BAKERS HOUSE

25 Bakers Road, Uxbridge, UB81JY

15th November 2019

This Addendum Design Statement describes in detail all the architectural changes made.

Title
Site Development Plan

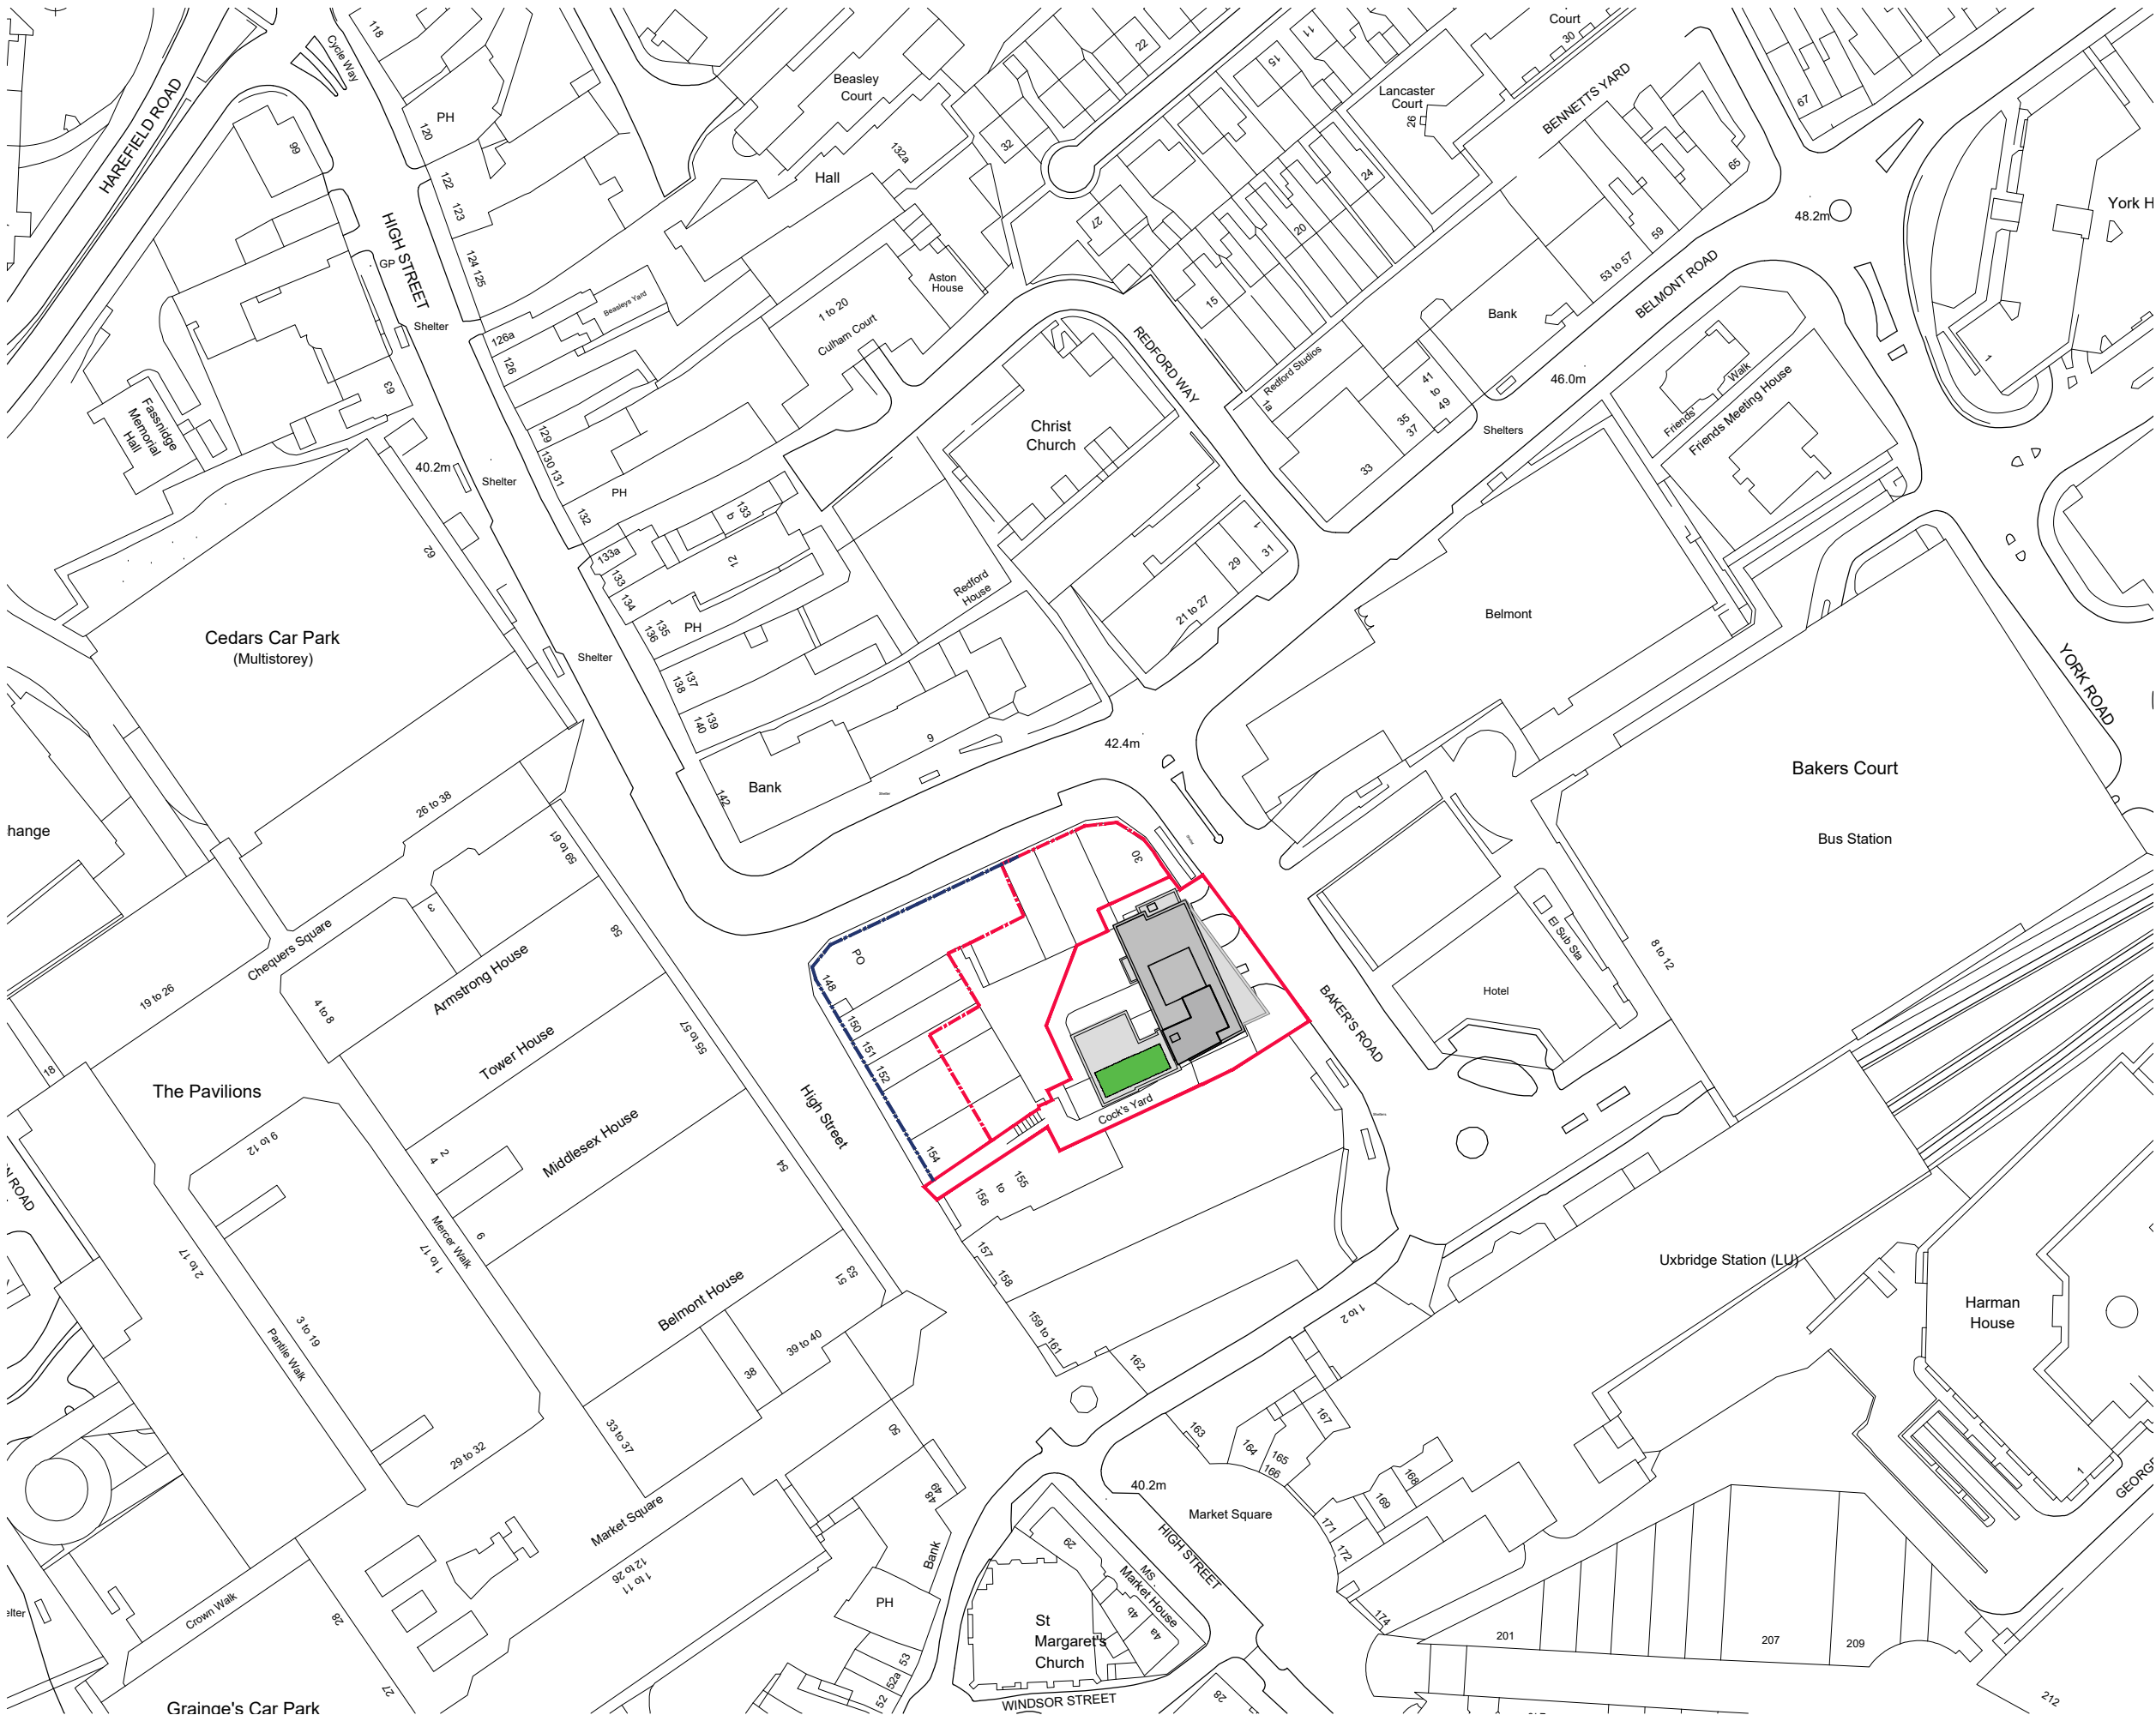
- *Highways* – that the scheme should introduce improved kerb alignments for vehicles exiting the site.
- *Parking* – that disabled spaces in the car park need to be closer to the hotel lobby.
- *Accessibility* – that at least 10% of rooms need to be wheelchair accessible.
- *Roof plant* – that the scheme should remove visual clutter at roof level.

The revised scheme eases the kerb line at the exit point from the ground floor service yard, to meet comments raised by Hillingdon's highways engineers.

The
NW, SW & Long Section Elevations D-D E-E
Bakers Rd/Cocks Yard

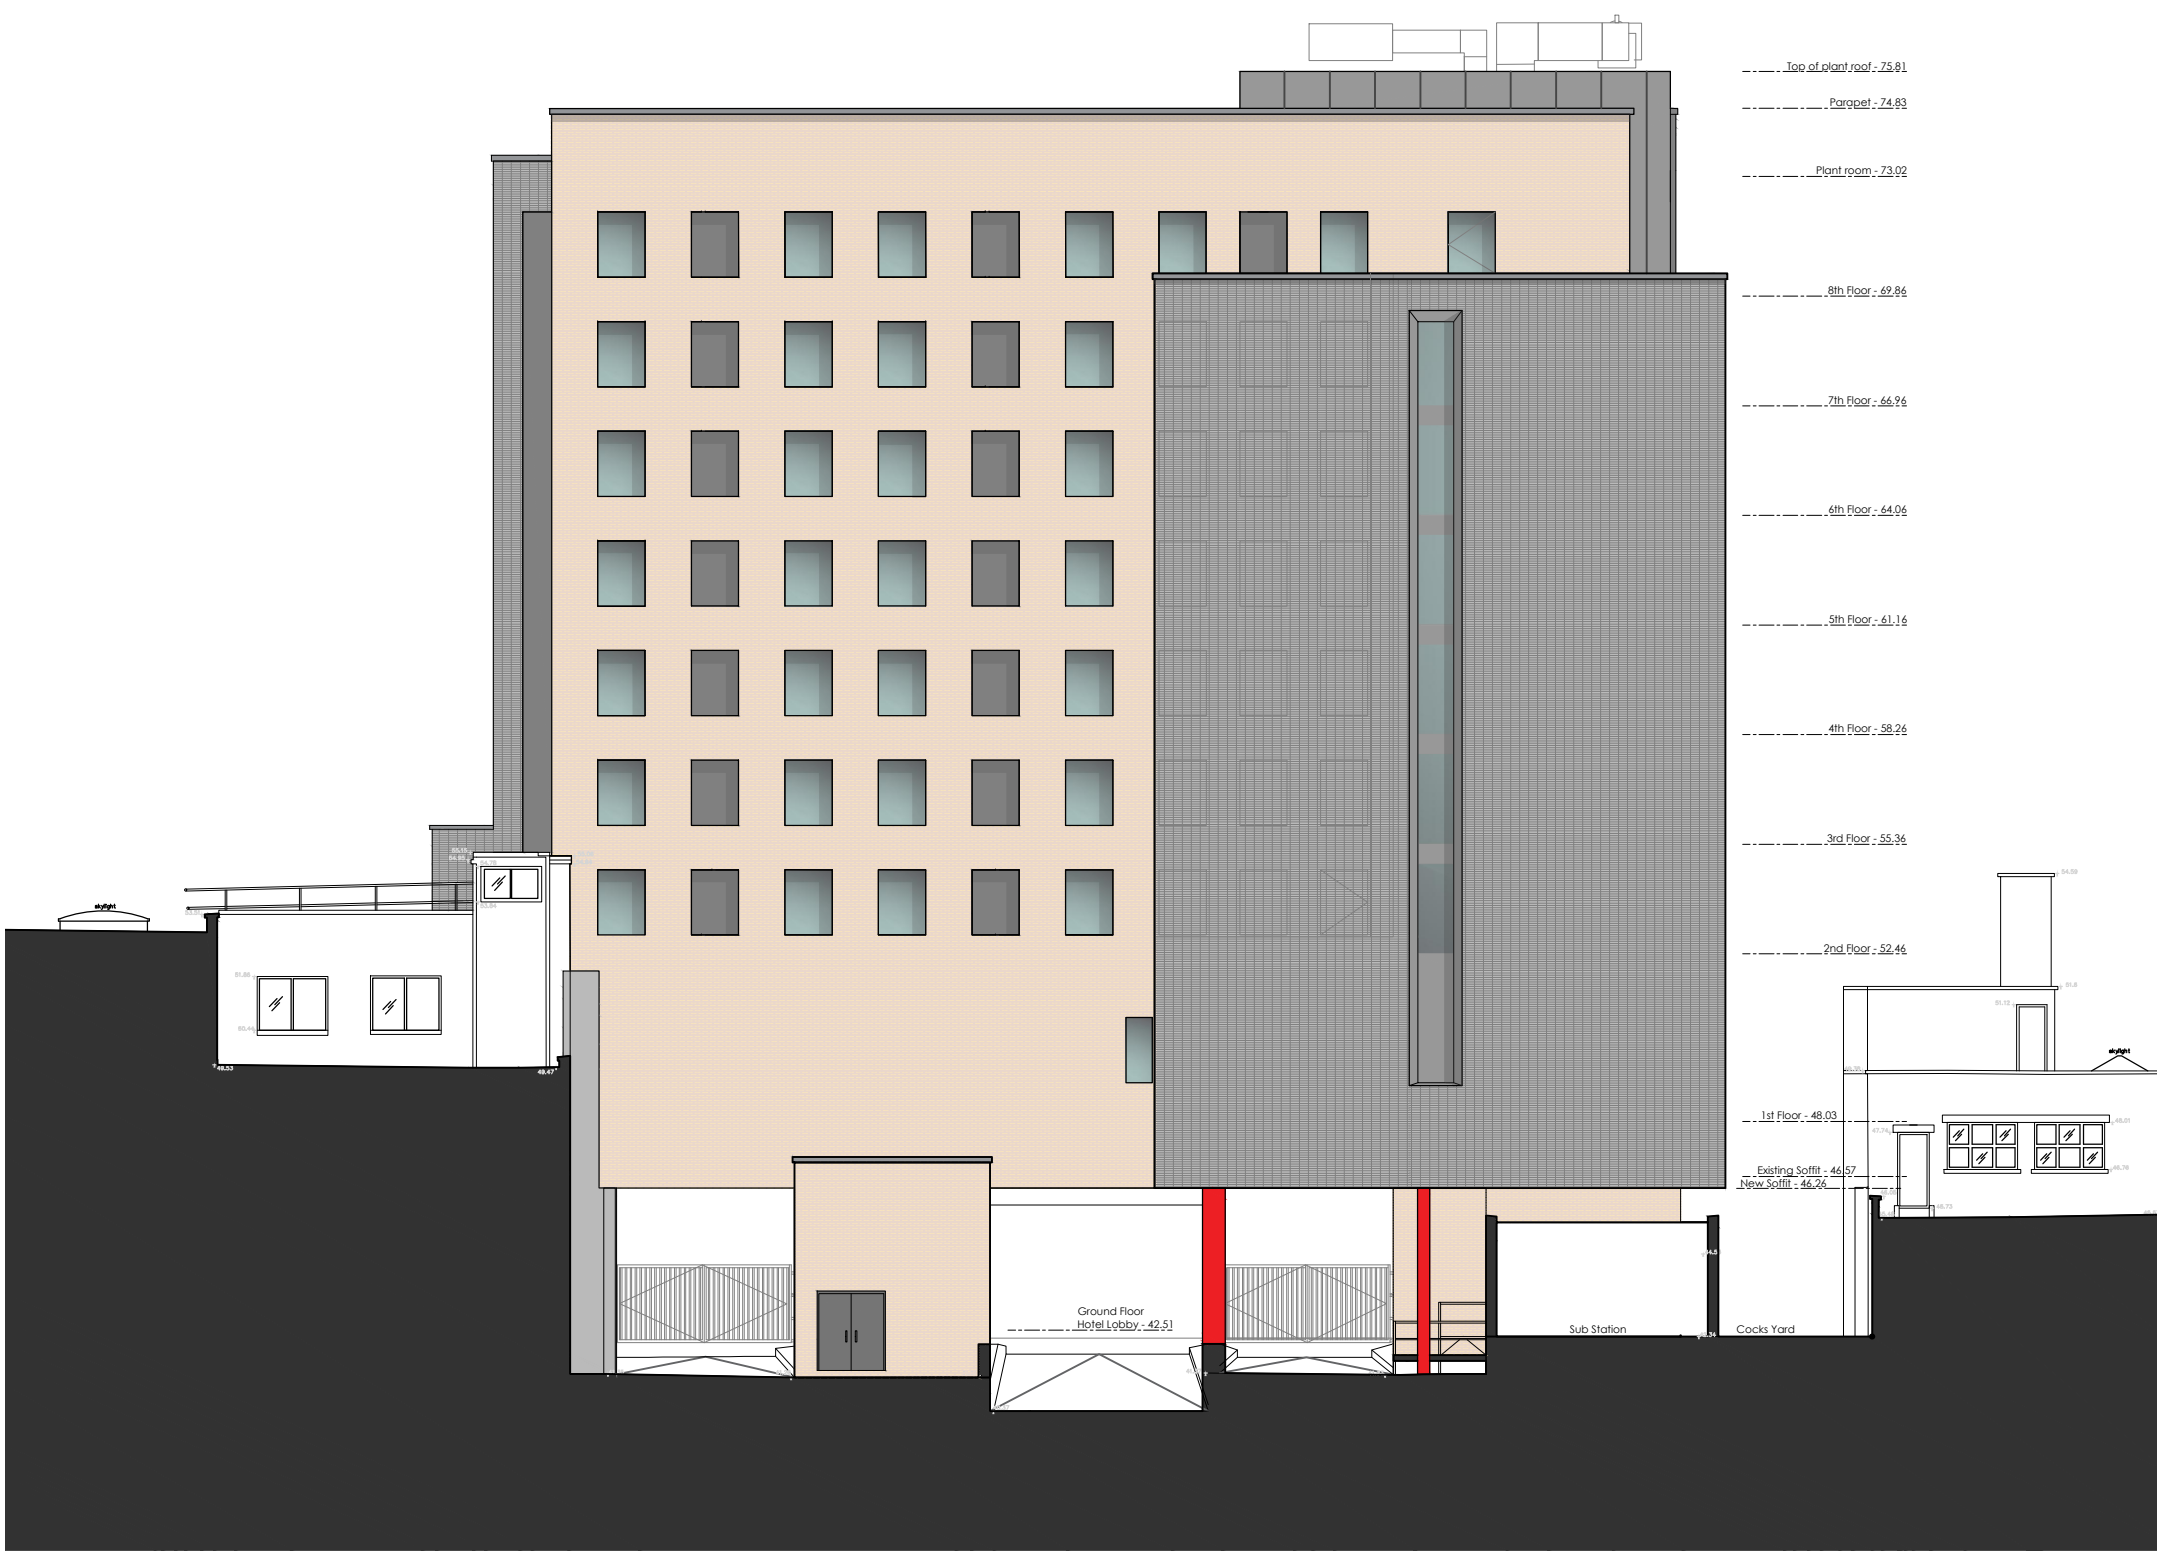
- *Massing* – that the existing varying heights and protrusions would benefit greatly from a simpler built form.
- *Cladding* – that the scheme limits the palette of materials used, and avoids the use of render.
- *Fenestration* – that the scheme introduces windows on blank gable elevations, provides further definition of the façade detailing (including window reveals), and removes unsightly ventilation outlets.
- *Security* – that the scheme should avoid creating 'hidden' corners on Cocks Yard, which might encourage

We have now introduced windows on the previously blank north elevation to light the secondary stair. These provide greater interest in views from Belmont Road. If the remainder of the Belmont Road retail block were to be developed (see 'Anticipating Further Development' on page 56 of the original DAS), these new windows would be blanked off. Our clients have retained the right, within their legal agreement with the hotel operator, to impose this.

Similar 'gable' windows have been introduced on the south-east elevation, where they help light the desk area of the new corner room.

At ground floor level in the original application, Cocks Yard was mostly faced up with a solid brick wall and an escape door from the internal fire staircase. The revised scheme introduces more transparency by extending a wide staircase window down to ground floor level. Further fenestration at ground floor is difficult, but the ground floor is not tall, and bedroom windows from first to seventh floors (incl.) provide the necessary vitality and surveillance needed over this part of the pedestrian link.

Our revised scheme now omits the red brick and render altogether, and limits the proposed palette of materials to the grey and buff bricks. The buff brick now extends around and across the rear elevation, so that even though sight of this is limited to one view from the High Street, a consistent quality of finish is still evident.

The idea of visually separating the Cocks Yard elevation into two different buildings using different heights and materials is still pursued, but again only using the grey and buff bricks.
